APPLICATION BY NNB GENERATION COMPANY (SZC) LIMITED FOR AN ORDER GRANTING
DEVELOPMENT CONSENT FOR THE SIZEWELL C PROJECT

AMENDMENT TO THE APPLICATION AND INCLUSION OF ADDITIONAL LAND

Submission to Planning Inspectorate on behalf of Suffolk Building Preservation Trust concerning the impact of proposals regarding Pakenham Fen and the operation of the historic Pakenham Water Mill. Updated 1 October 2021.

Figure 3.13a
Fen meadow compensation potential for Pakenham Fen north site

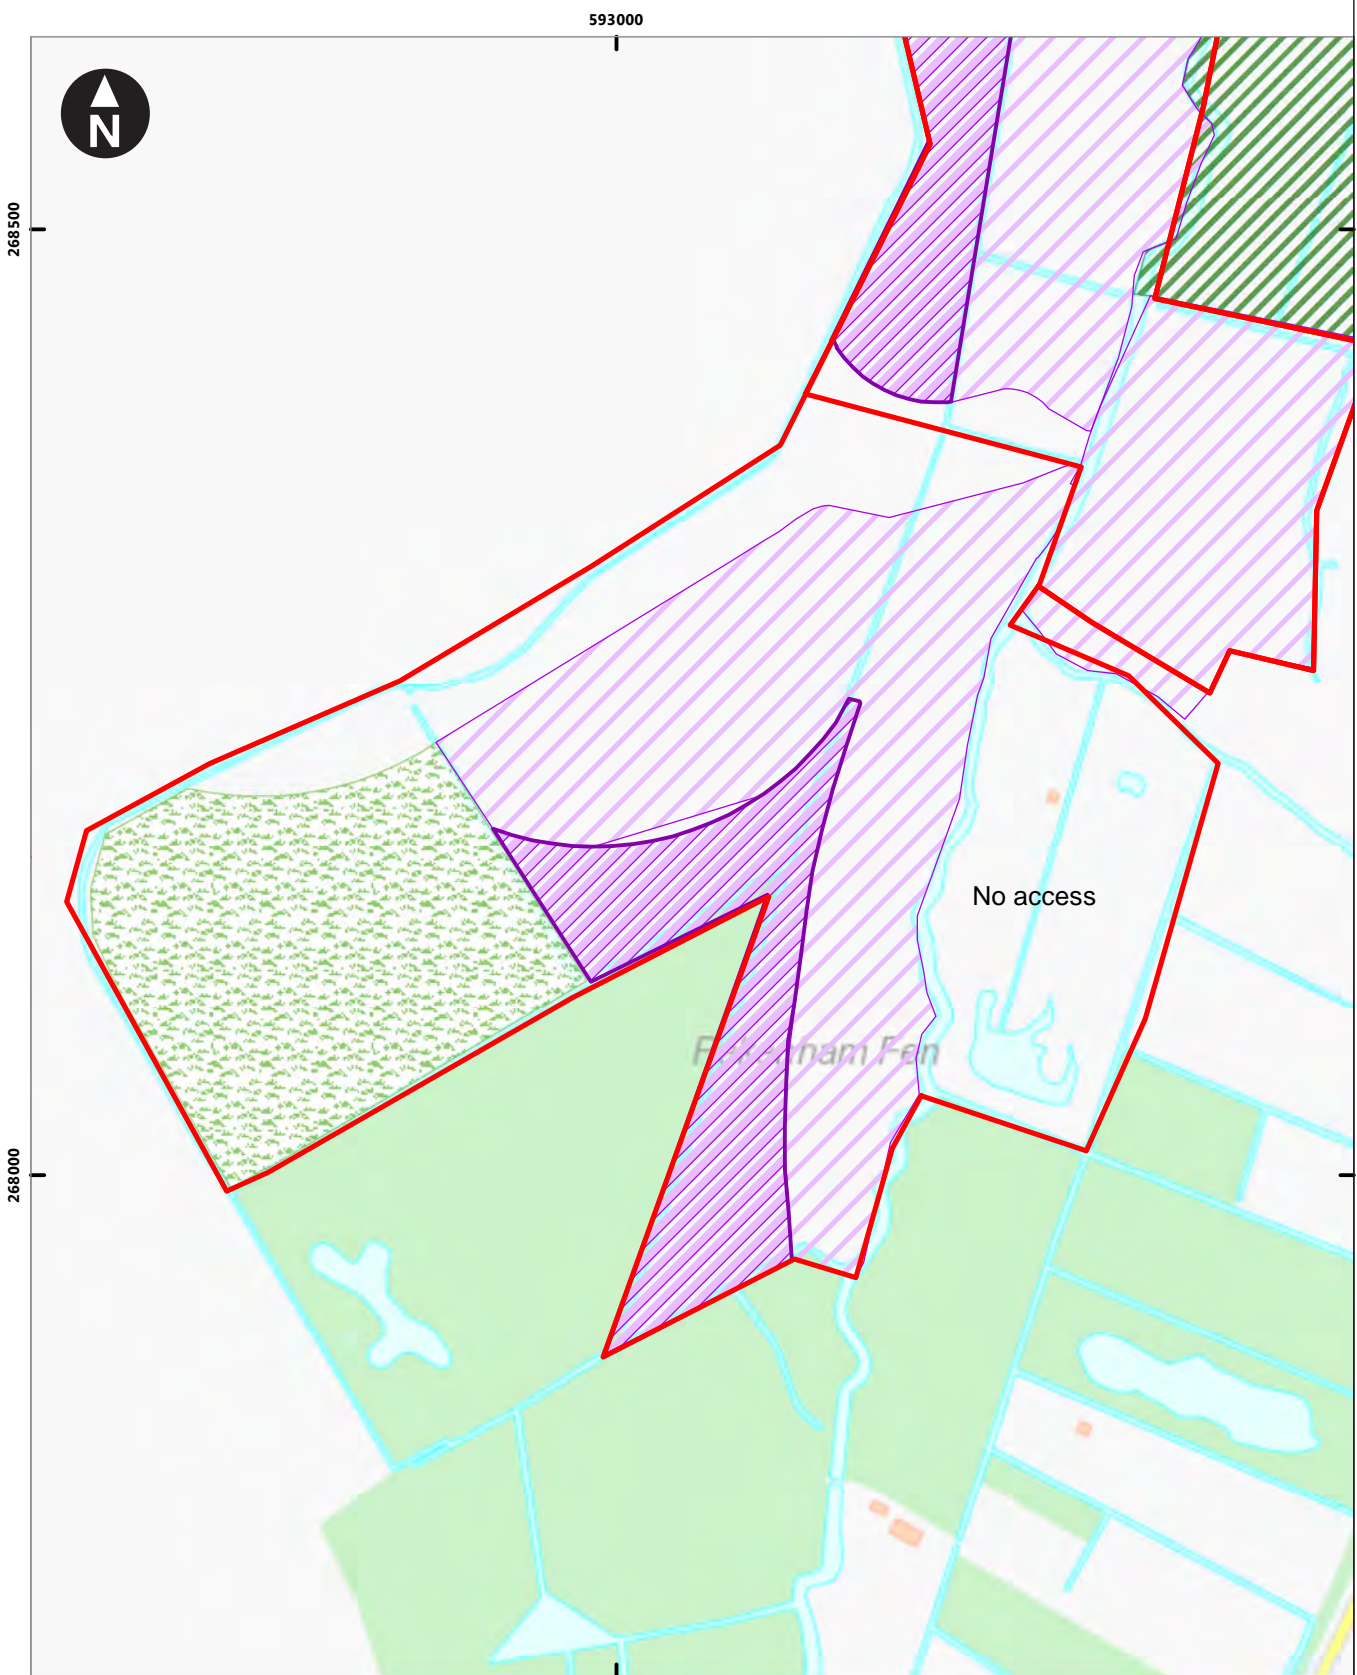
10. Report 9.64 proposes that that the surface level between the Central Ditch and Pakenham Stream in the Northern area will be lowered. There has been no assessment of how this will impact flow rates in Pakenham Stream, and therefore influence Pakenham Mill which lies downstream of this area.

11. Report 9.64 notes at section 4.5.8 that the “leak” from Pakenham Stream supports the ditch water levels on the proposed site and therefore should be retained. However, the report does not mention that this breach is due to poor maintenance of the riverbanks by the riparian owner, and is not a naturally occurring feature. Therefore, it cannot be relied on as a source of water to the Central Ditch and must be repaired.

12. There is significant concern that if this “leak” is not repaired it will be later relied on to raise groundwater levels in the proposed fen creation east of the “Central Ditch”. This will have a significant and negative effect on the water supply to Pakenham Mill and therefore its ability to operate.
